RE: Transmittal of Comments – Dicken Luft Short Plat (SP-09-00013)

RE: Dicken/Luft Short Plat SP-09-00013

SUBJECT: Dicken Luft Short Plat SP-09-00013

Thank you for the opportunity to comment on the short plat of approximately 50.6 acres into 4 lots within the Commercial Ag zoning district, proposed by Doug Dicken and Tom/Teresa Luft [SP-09-00013]. We have reviewed the application and have the following comments.

DICKEN/LUFT SHORT PLAT
 LOCATED IN SECTION 19, T. 17 N., R. 19 E., W.M.
 KITTITAS COUNTY, WASHINGTON

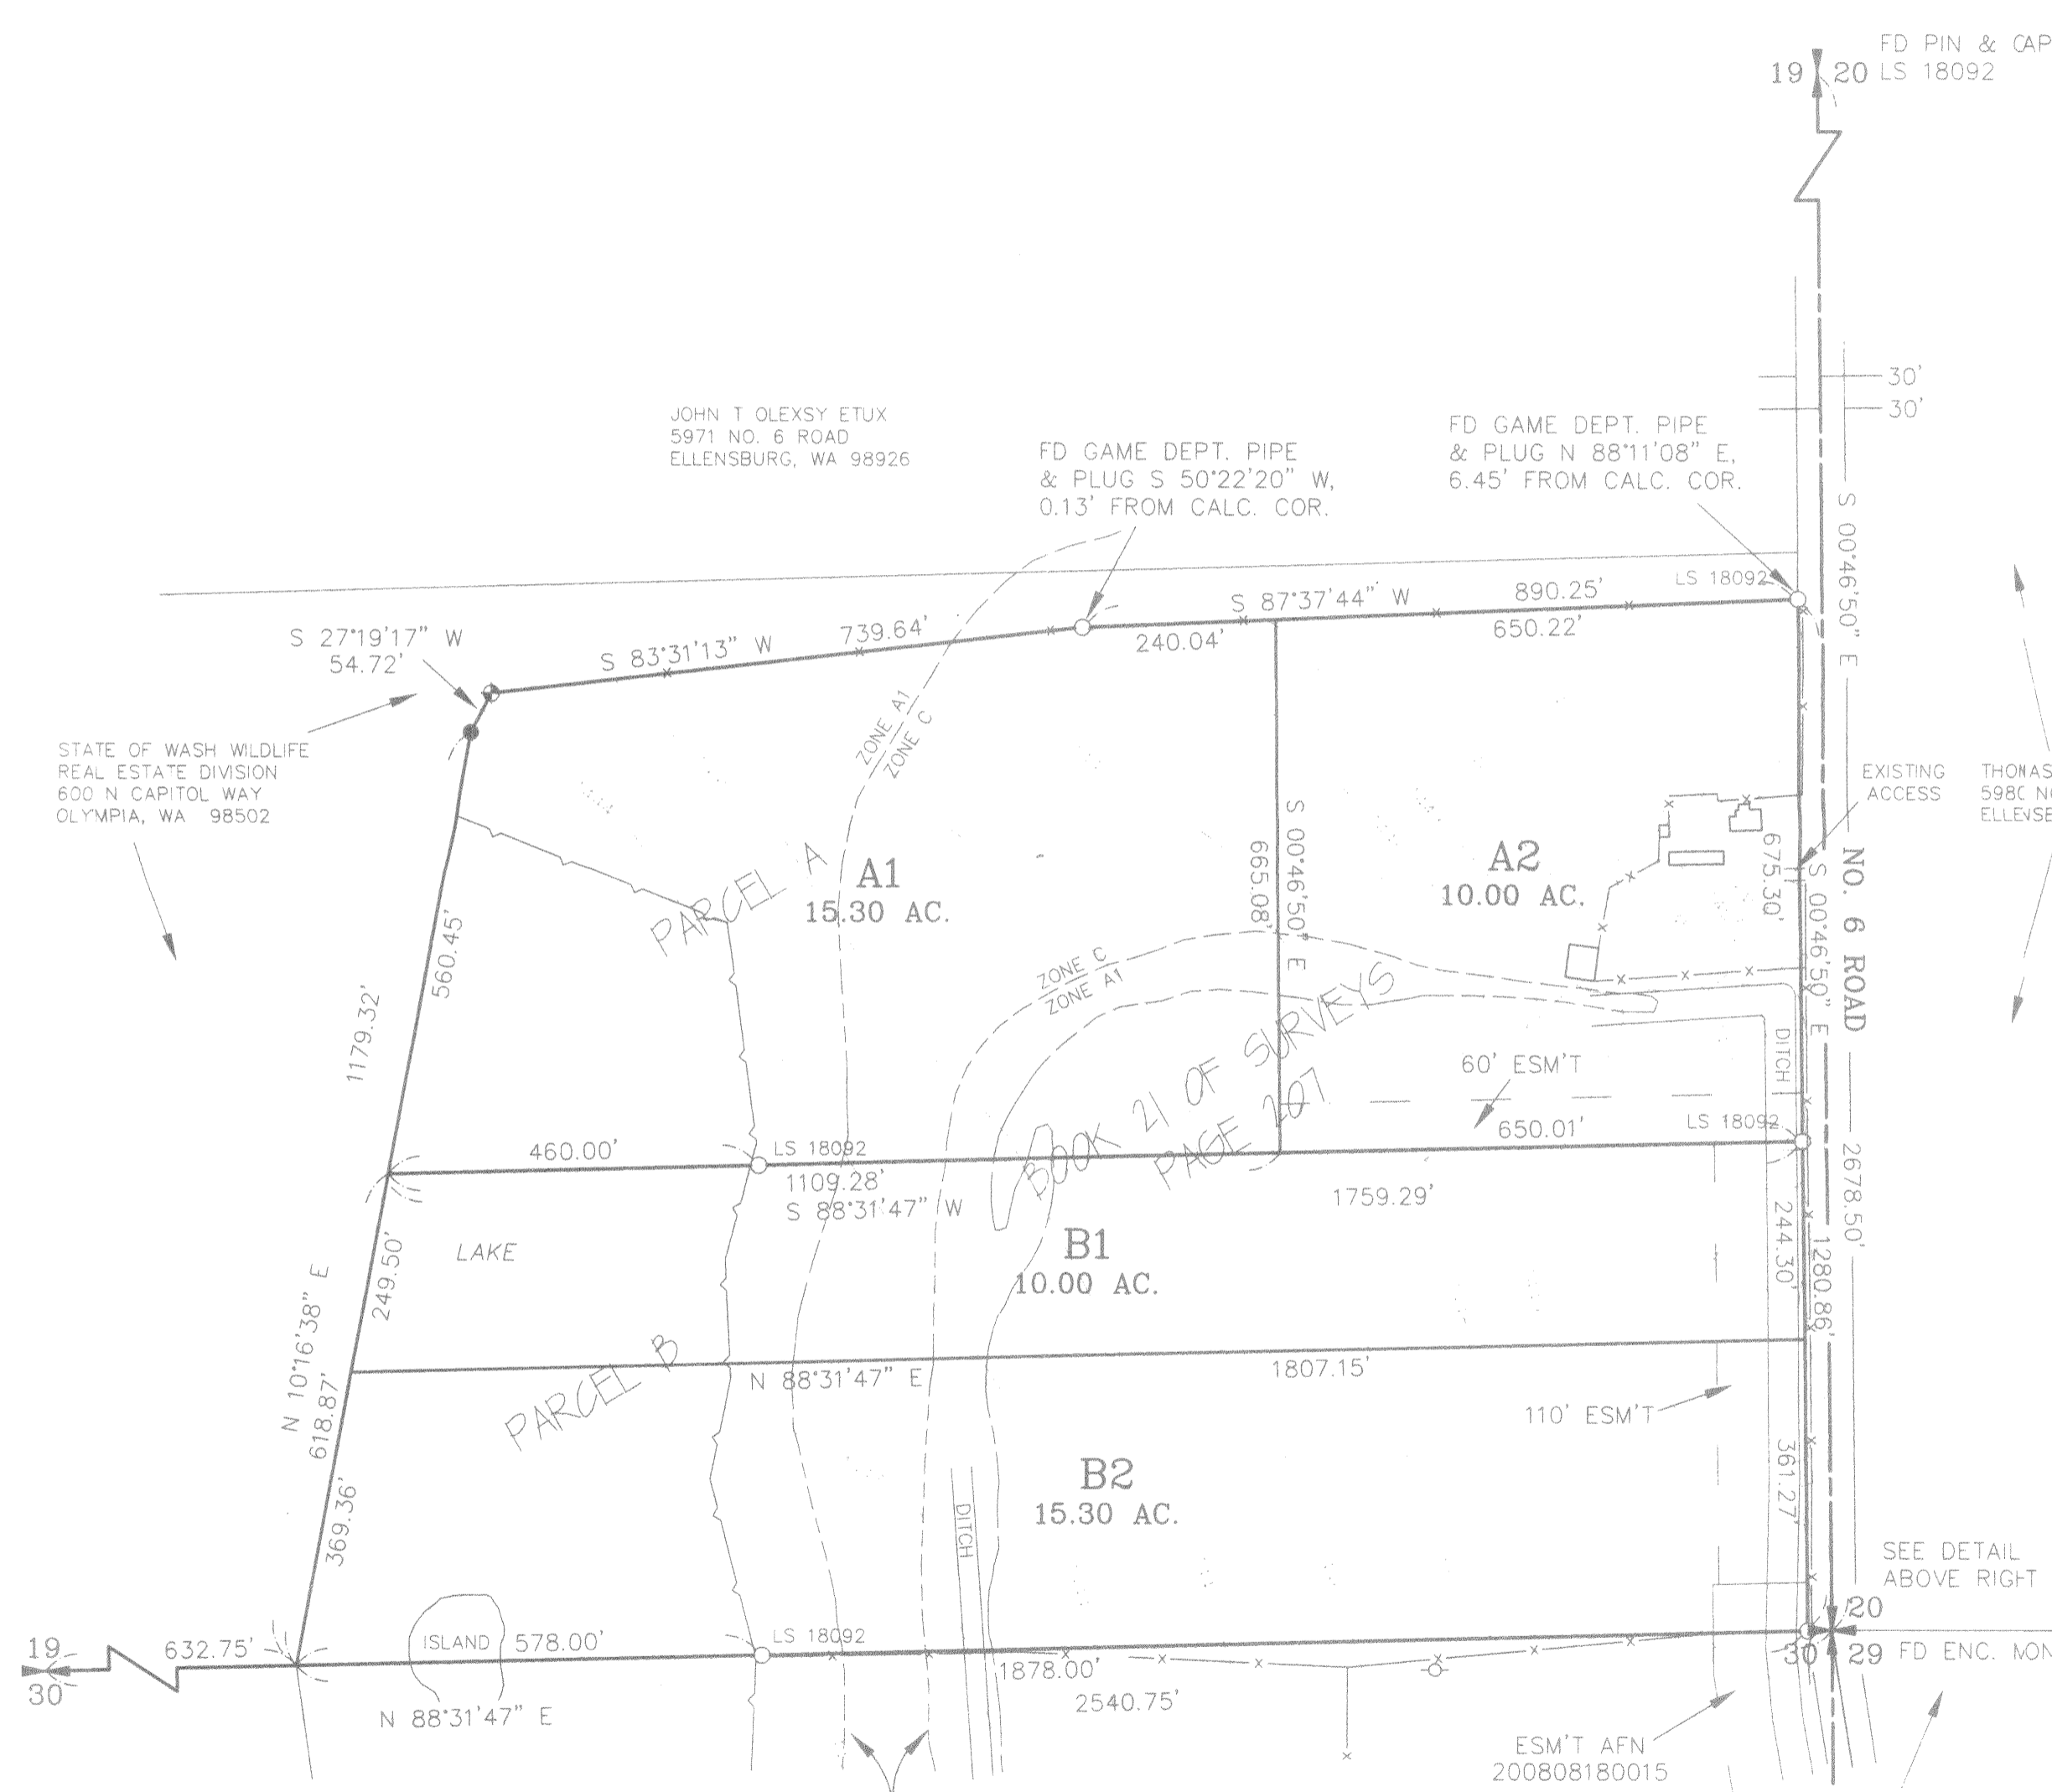
2. Access: No. 6 Road is classified as a Rural Minor Collector and all accesses must meet the 300' spacing requirement. A single-use driveway may be used to access Lot A1. A joint-use access may be used to access Lots B1 and B2. If access to Lots B1 and B2 is from Easement AFN 200808180015, the road must be constructed to Low Density standards as shown below, and a cul-de-sac constructed at the end of the road.

- c. Any further subdivision or lots to be served by proposed access may result in further access requirements.
4. Plat Note: Plat note 11 referring to determining access at the time of development shall be removed from the final plat.
